CITY OF ALBUQUERQUE

**RE: Lot 25 Block 6 Unit 18 SAD 228
6519 Pato Rd. NW
Volcano Cliffs Subdivision
Grading and Drainage Plan
Engineers Stamp Date; 9/19/19 (D10D003M25)
Pad Certification Date; 10/8/19
C.O. Certification Date; 6/3/2020**

505-249-4843 donbriggsengineering@gmail.com 5324 Oakledge Ct. NW, Albuquerque, NM 87120	
TITLE: 6519 Pato Rd. NW Grading & Drainage Plan			
Design Review Committee	City Engineer Approval	Last Design Update	Mo. / Day / Yr.
City Project No.	Zone Map No.	Sheet	Of

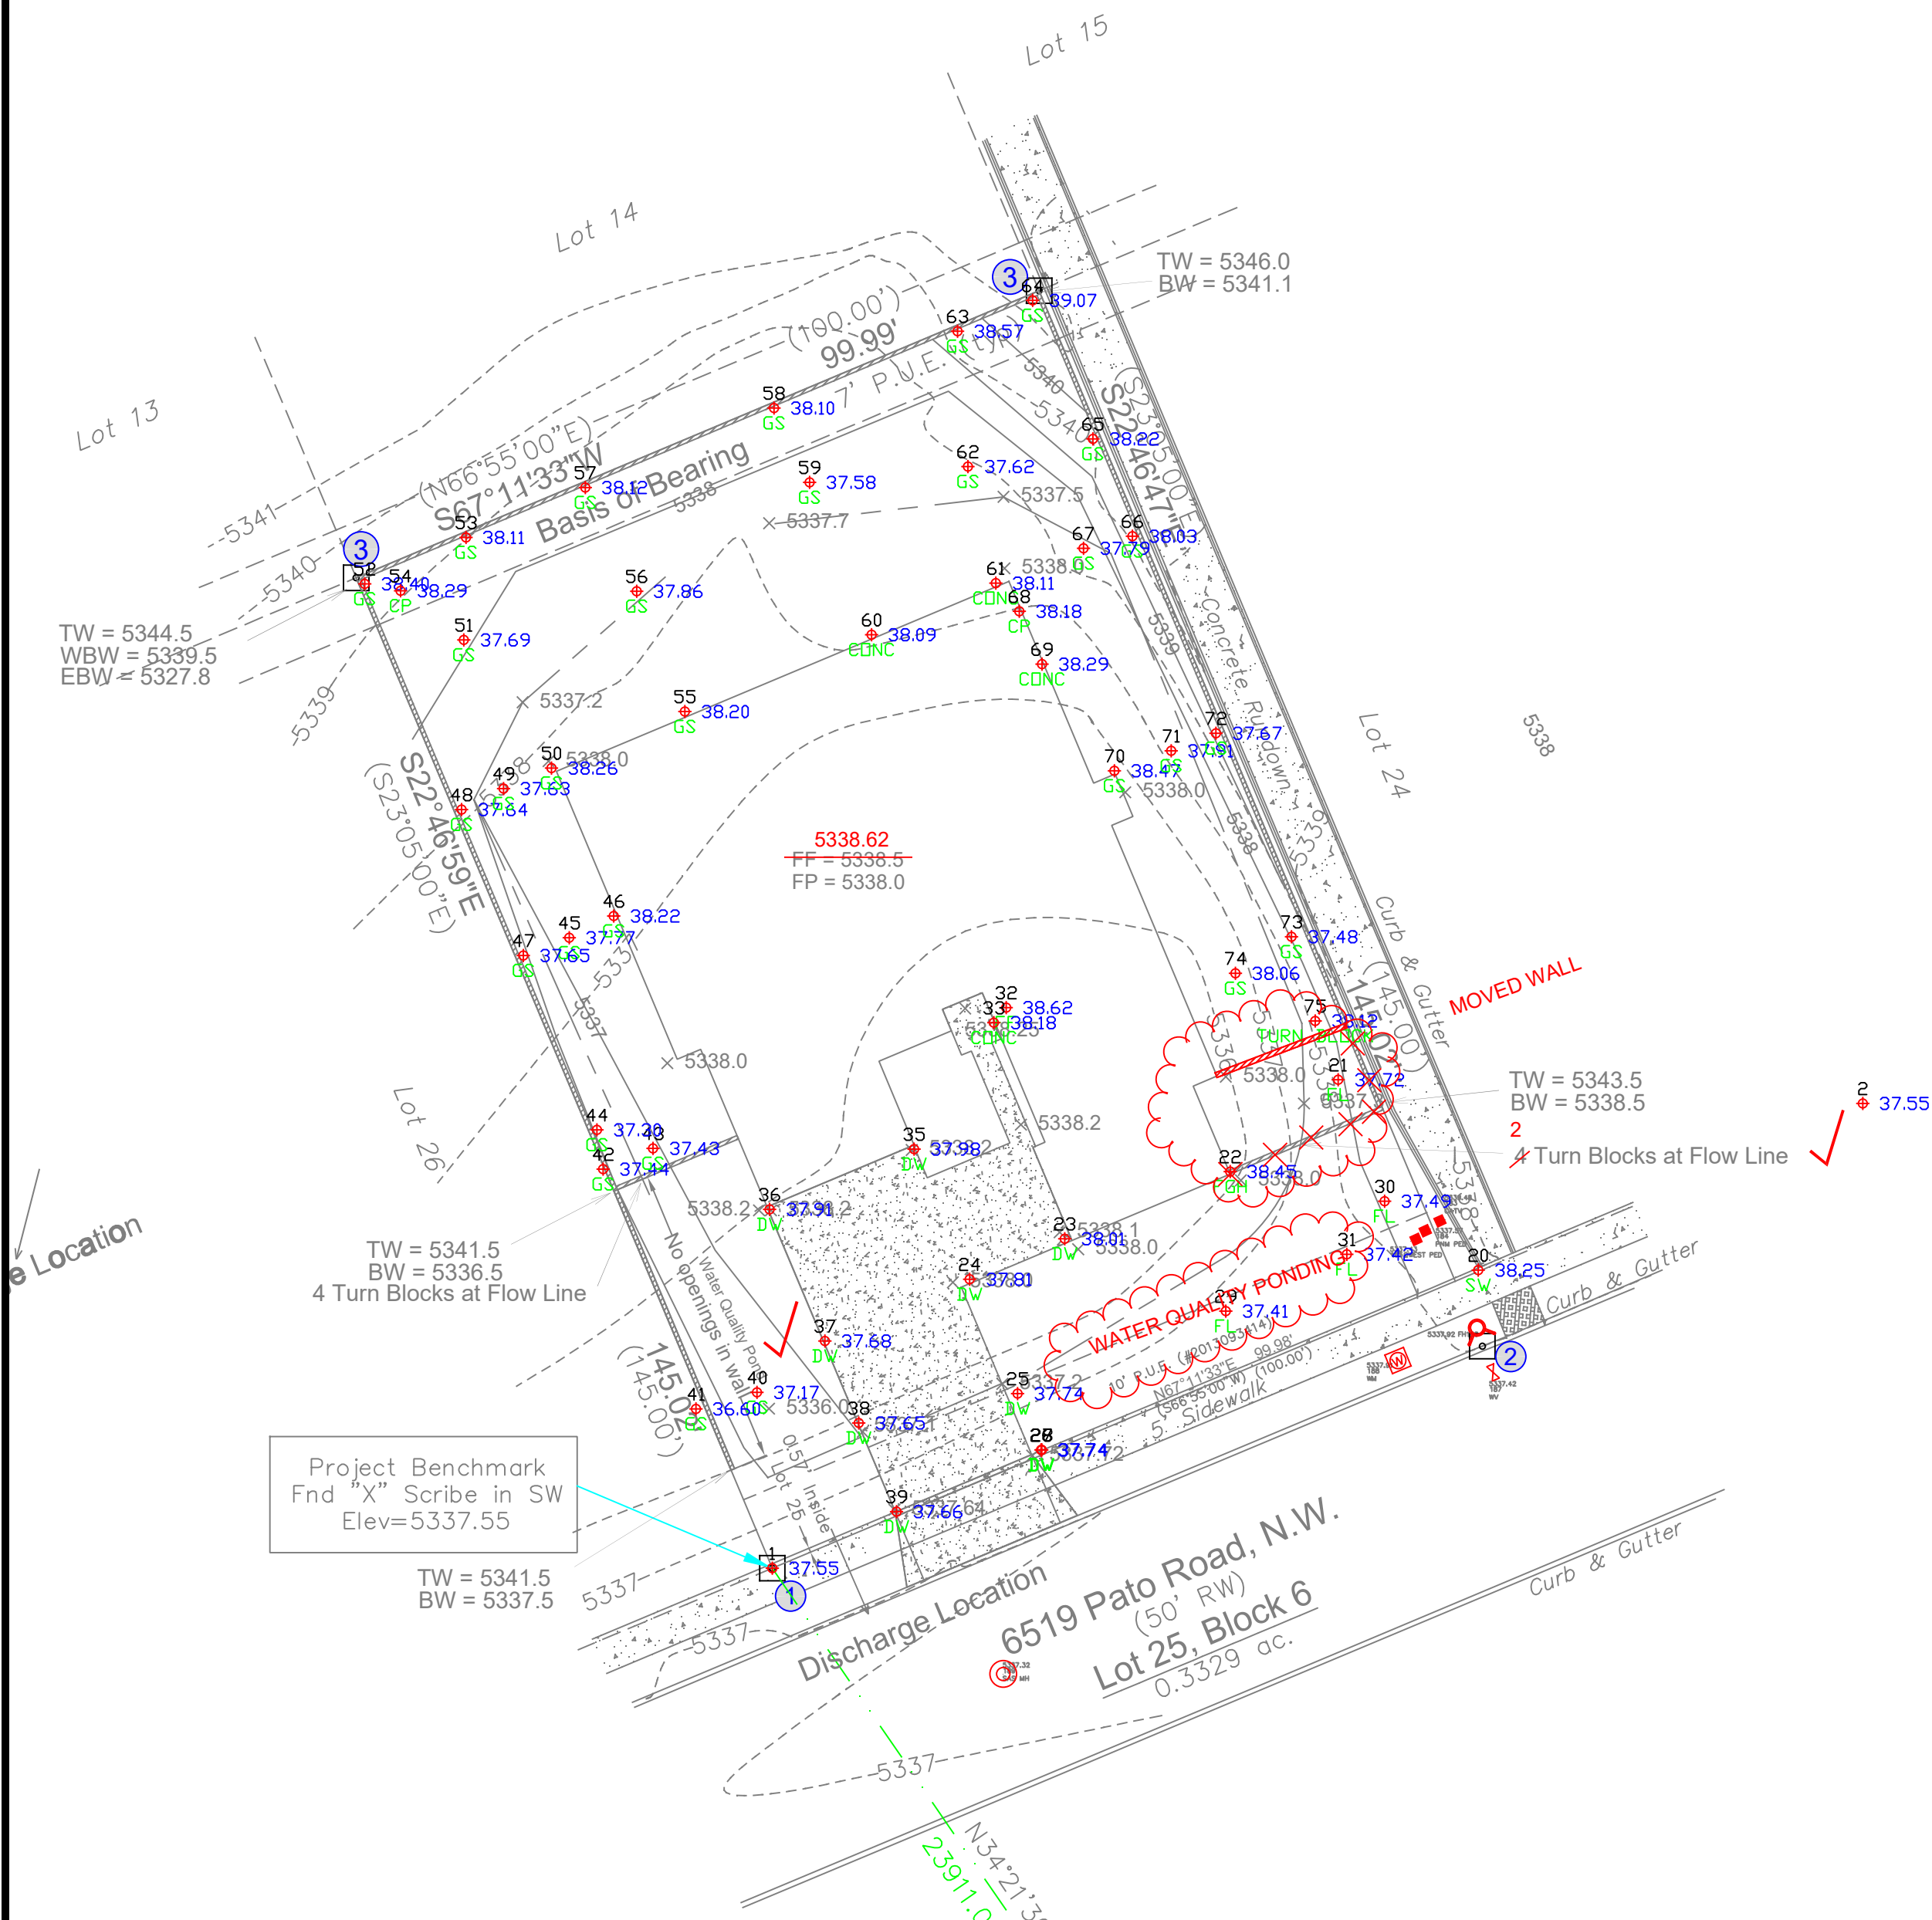
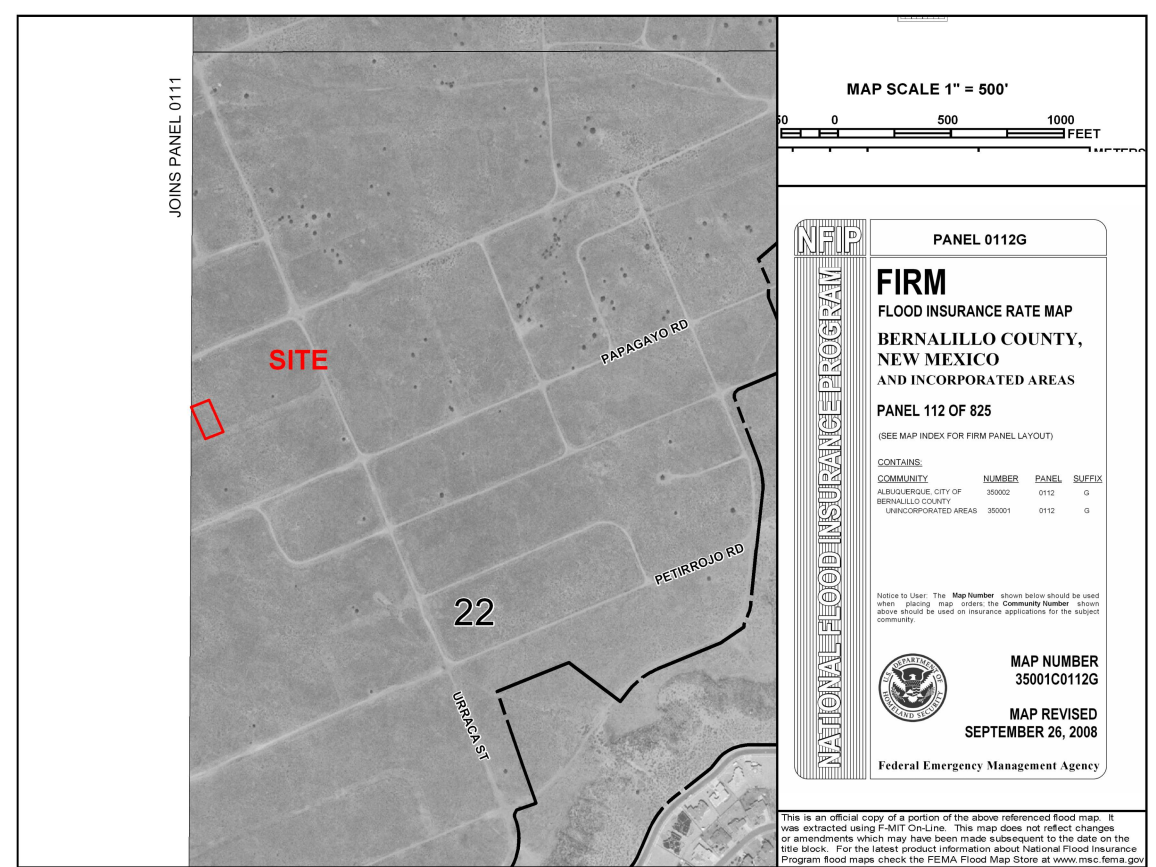
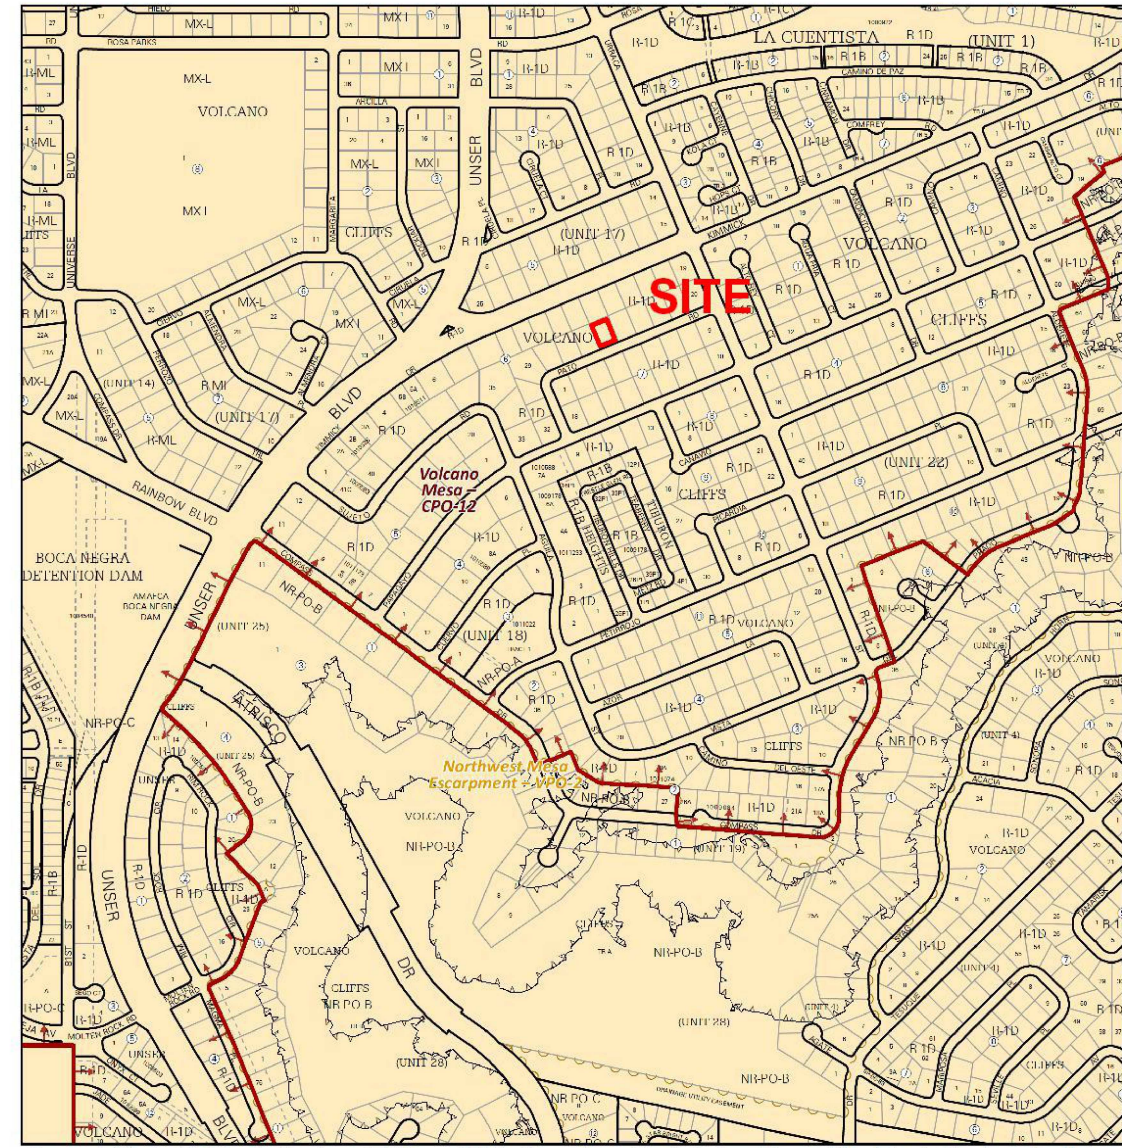
- Provide a new date for the changes to the plan.
- Provide the approved Pad Cert. language on the plan.
- Provide a statement that the plans are ready for CO.
